Green Hill Solar Farm

EN010170

Statement of Common Ground: Environment Agency Revision **BC** (Tracked)

Document Reference: ~~EX6~~ EX6/GH8.3.5_ BC

Drawing file: published-documents / EN010170-001289-GH6.4.4.15_B_ES Figure 4.15_Landscape and Ecology Mitigation Plan E_Sheet 2_Revision B (Tracked).pdf

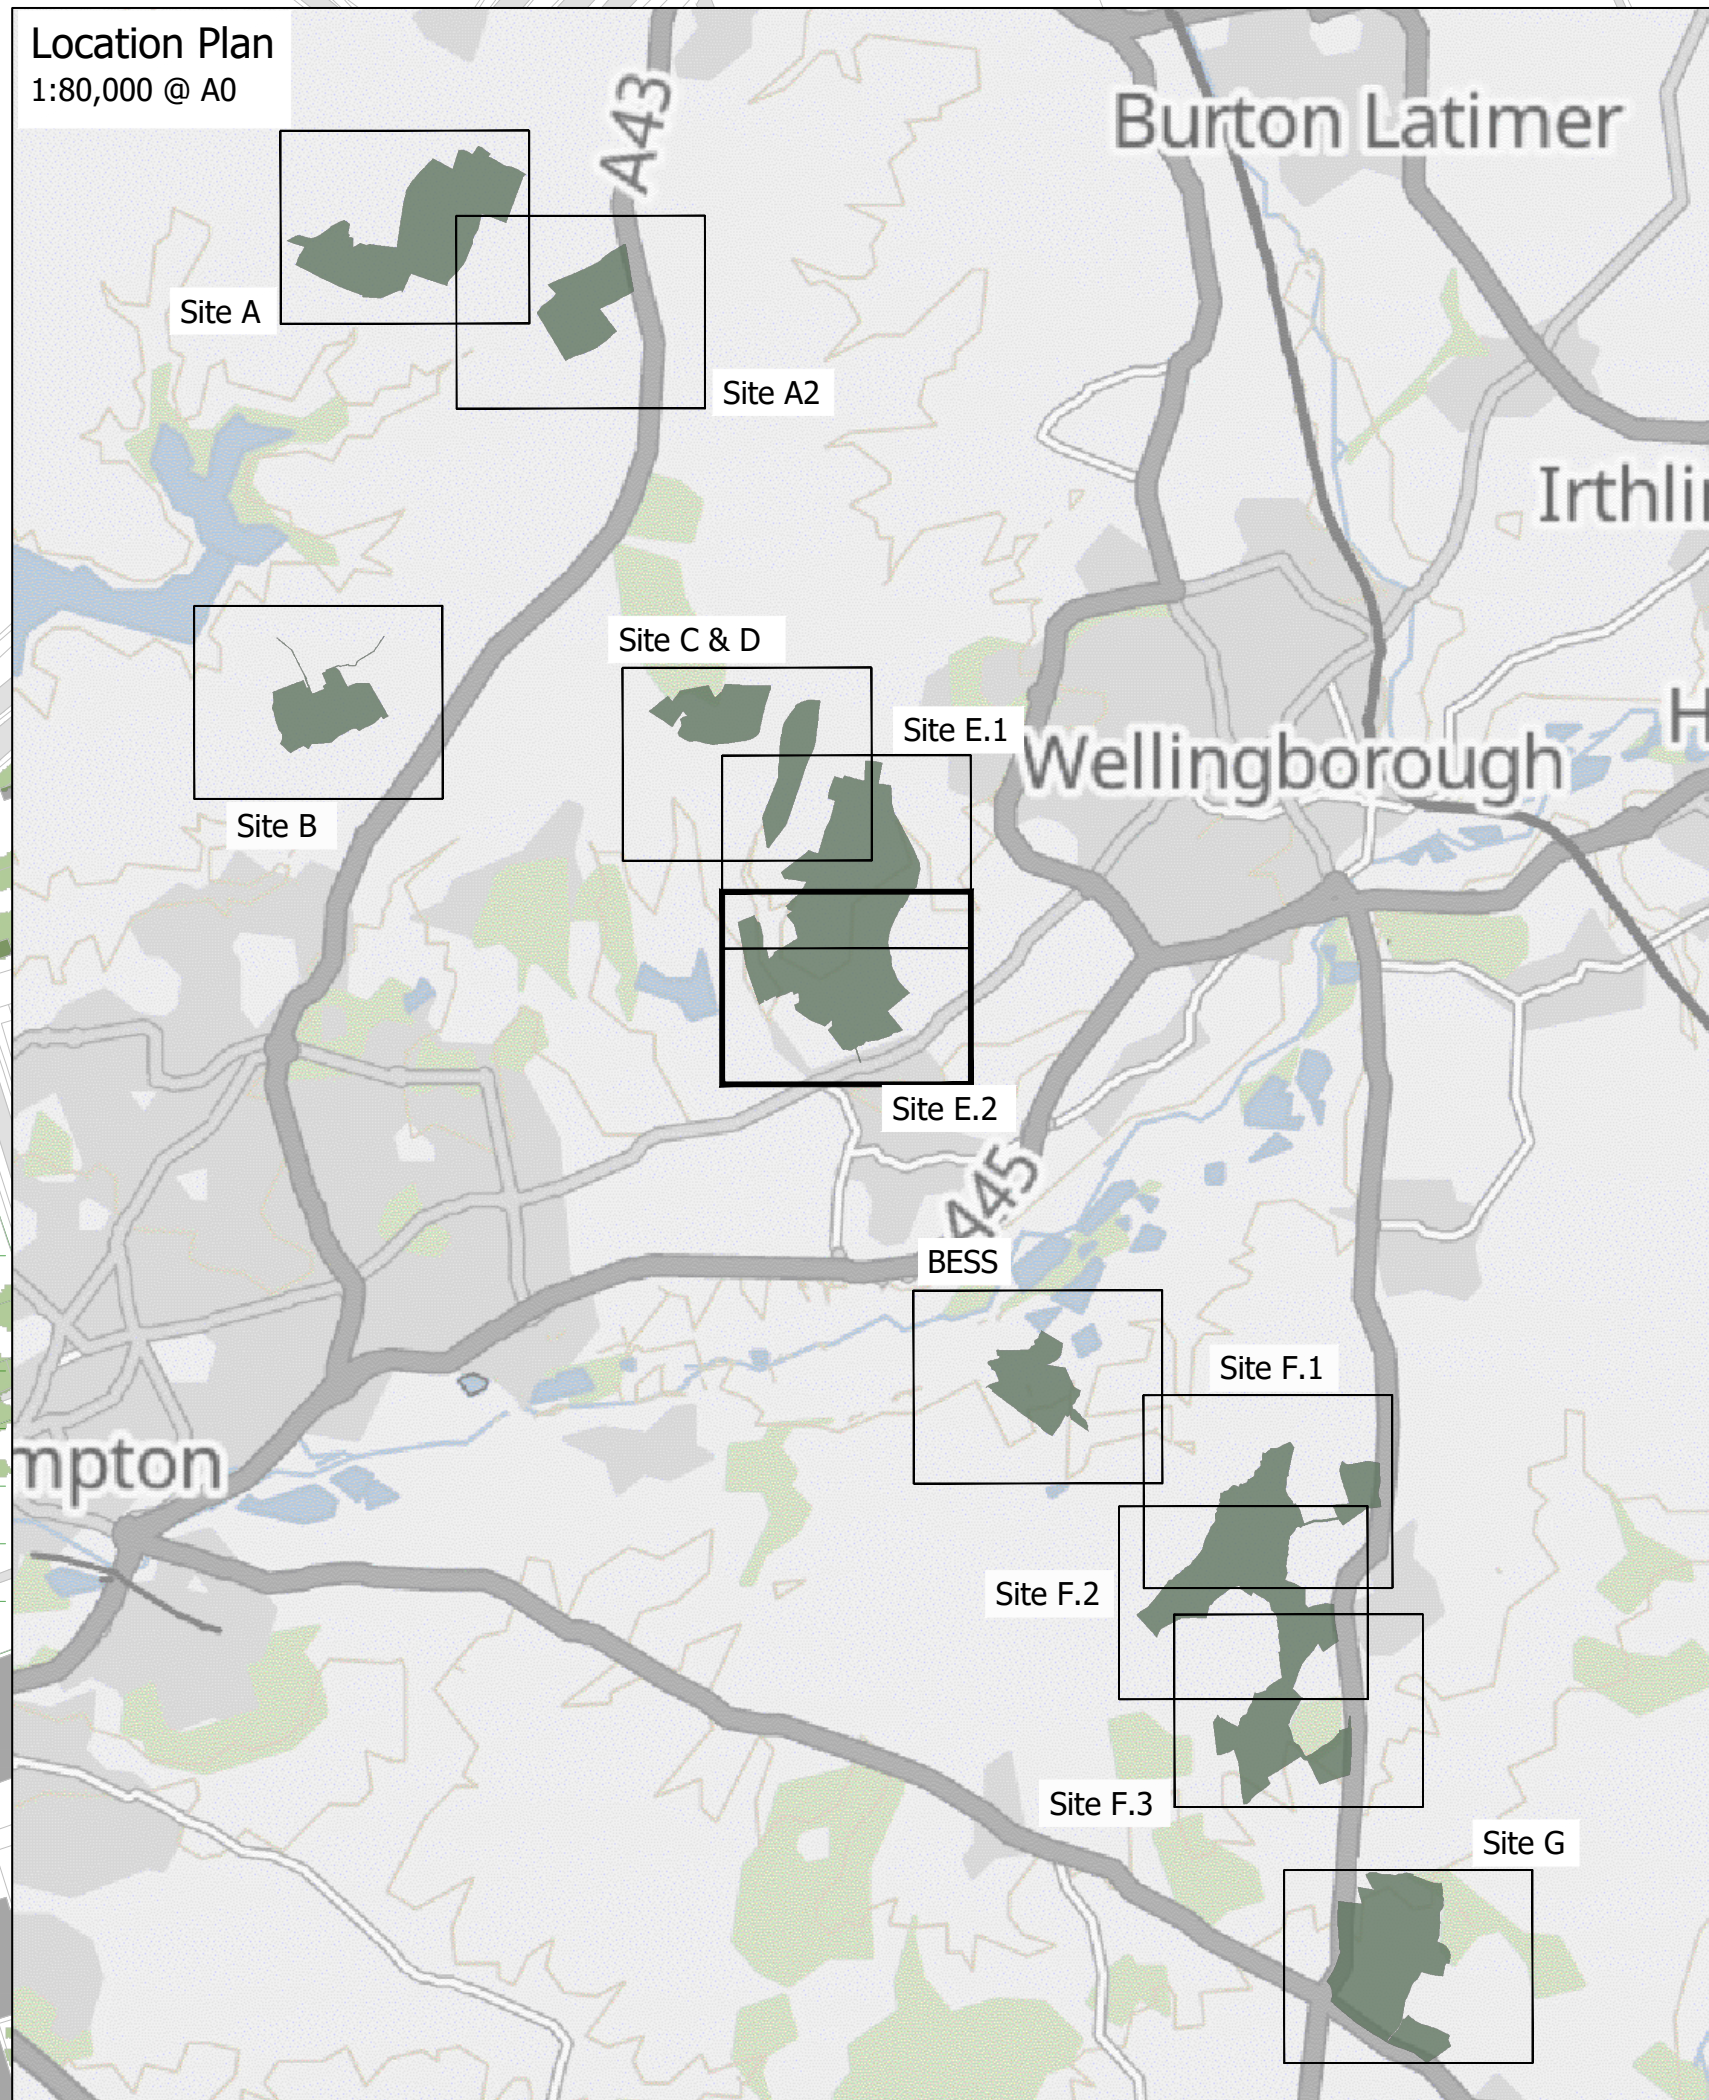
Matter	Details of Matters for Discussion	Applicant Position	Consultee Position	Status
			<p>Green Hill EF29 and EF30 do not include panels and are proposed areas of diverse wildflower meadow as shown on ES Figure 4.15 Landscape and Ecology Mitigation Plan E (Sheet 2) [EX6/GH6.4.4.15 C].</p> <p>Panels within Green Hill EF27 been offset from Hockerhill Farm. Based on a review of approximate markup provided by the Environment Agency and Ordnance Survey data, the panels appear to be appropriately offset from the identified spring.</p> <p>If springs were present and contributing to a wet habitat (such as a watercourse or wet grassland), these habitats would have been recorded as such during the habitat walkover surveys. These surveys were completed at various times of year between August 2023 and September 2025 across the Order Limits, and plant communities associated with wet habitats</p>	<p>ground surface, held up by impermeable soils and rock.” – Freshwater Habitats Trust [accessed 16/03/26]</p> <p>It is pleasing to see that the headwaters of the watercourses identified in Chapter 10 of the ES will be subject to the suggested buffers included in the protection framework.</p>
